Marge Schmuckal - 418 Woodford Street

From: Marge Schmuckal
To: balancedbuilding@yahoo.com
Date: 7/18/2013 4:31 PM
Subject: 418 Woodford Street

2<sup>ND</sup> & 3<sup>RD</sup> FLOOR SECTION DETAIL  
UNIT 2

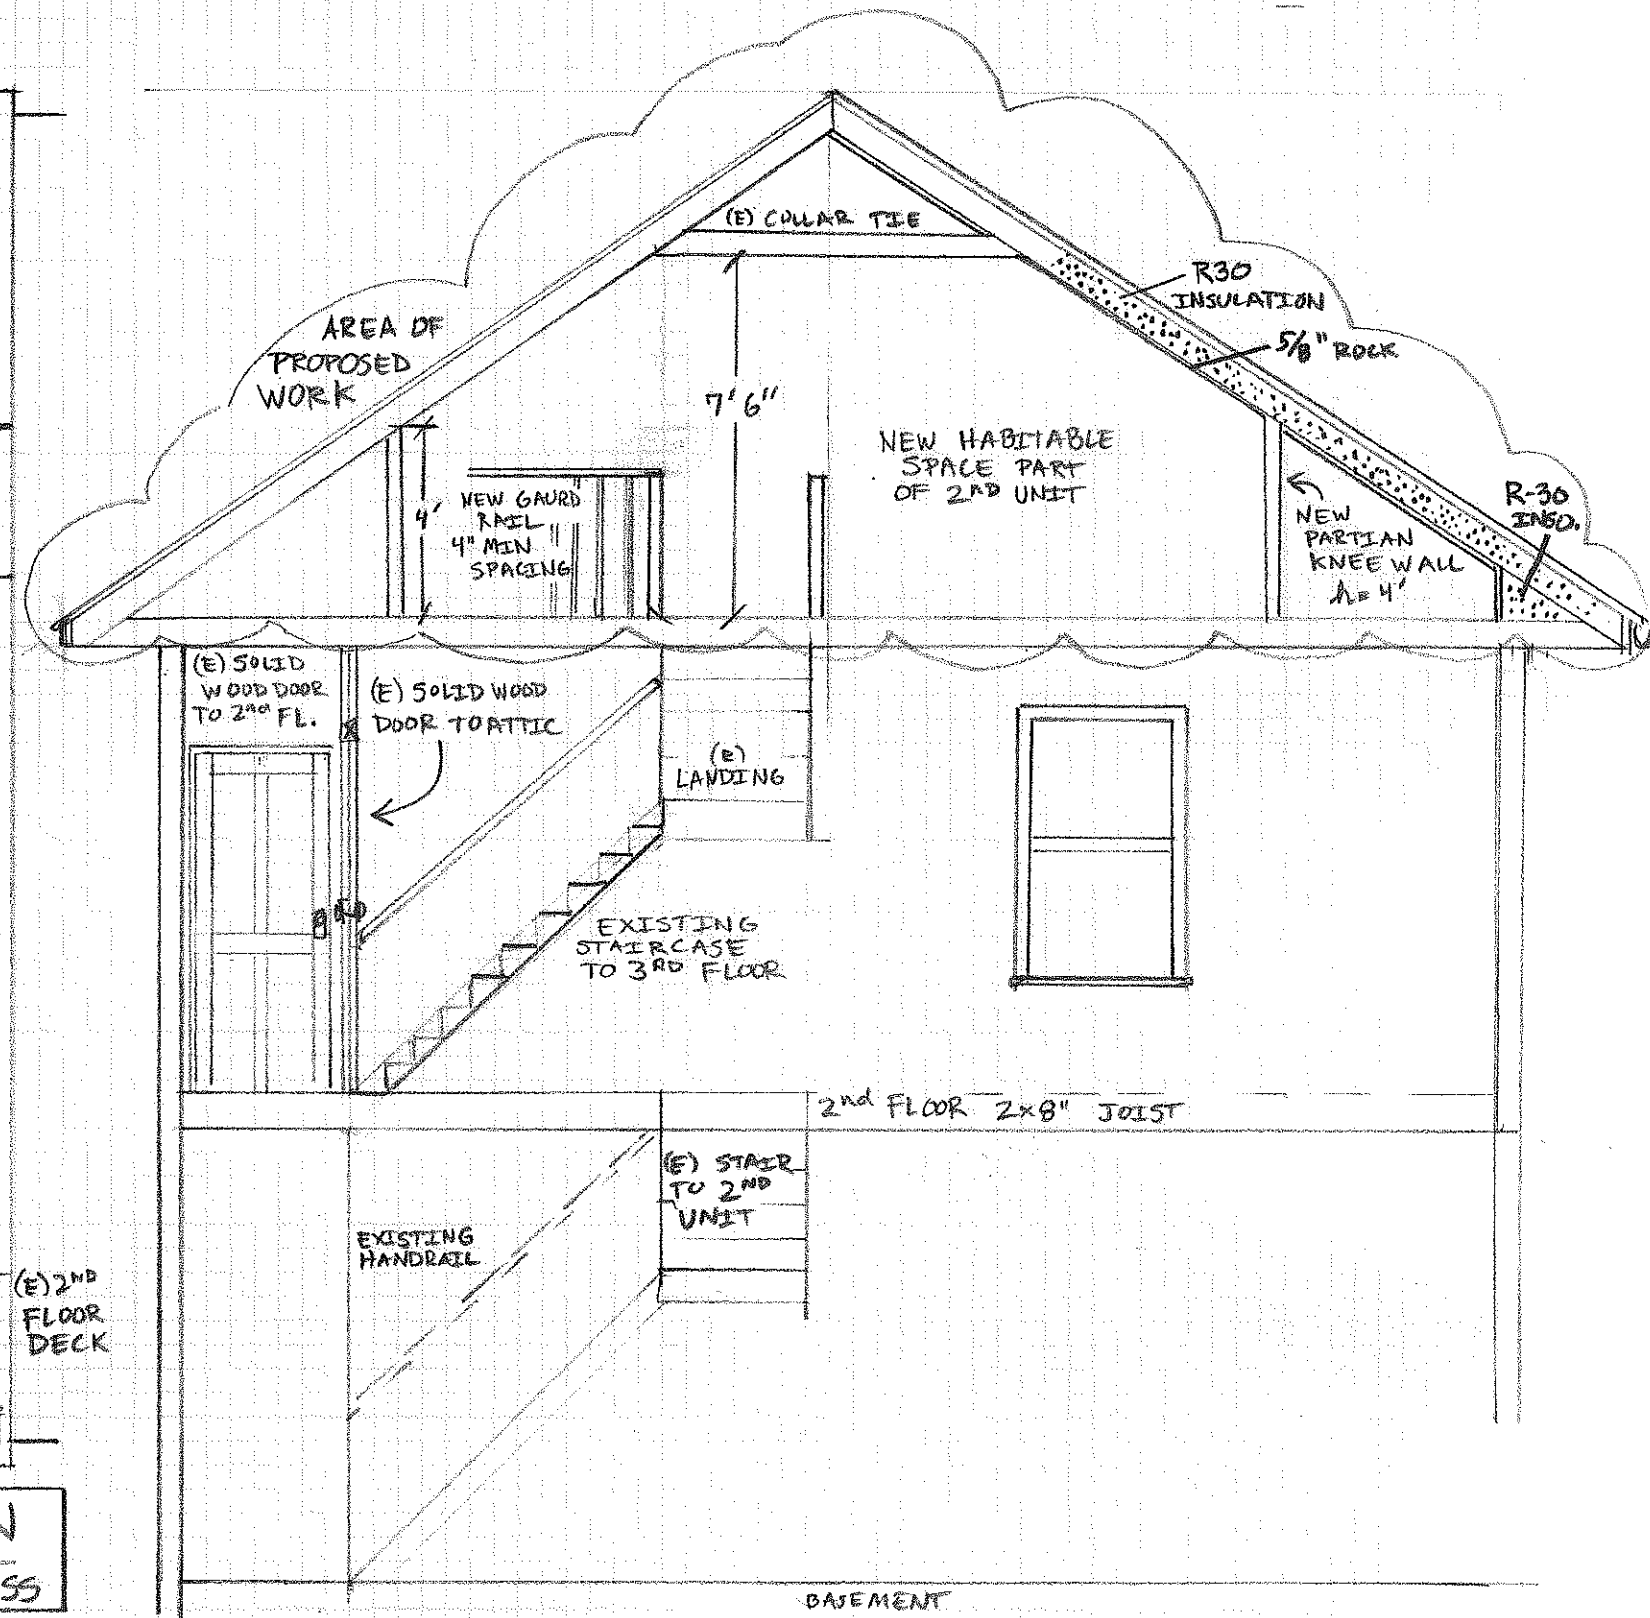
I have your permit application. I need more information to make a zoning determination. I would need a better cross section plan showing what is there now on the upper floor and what will be proposed. Under 14-436. Currently the building is not meeting all the R-5 zone setbacks so you are limited as to how you increase space going upward.

It is also obvious that this space is intended to be for habitation. I will need floor plans showing the layout of the floor and what use is intended for this area.
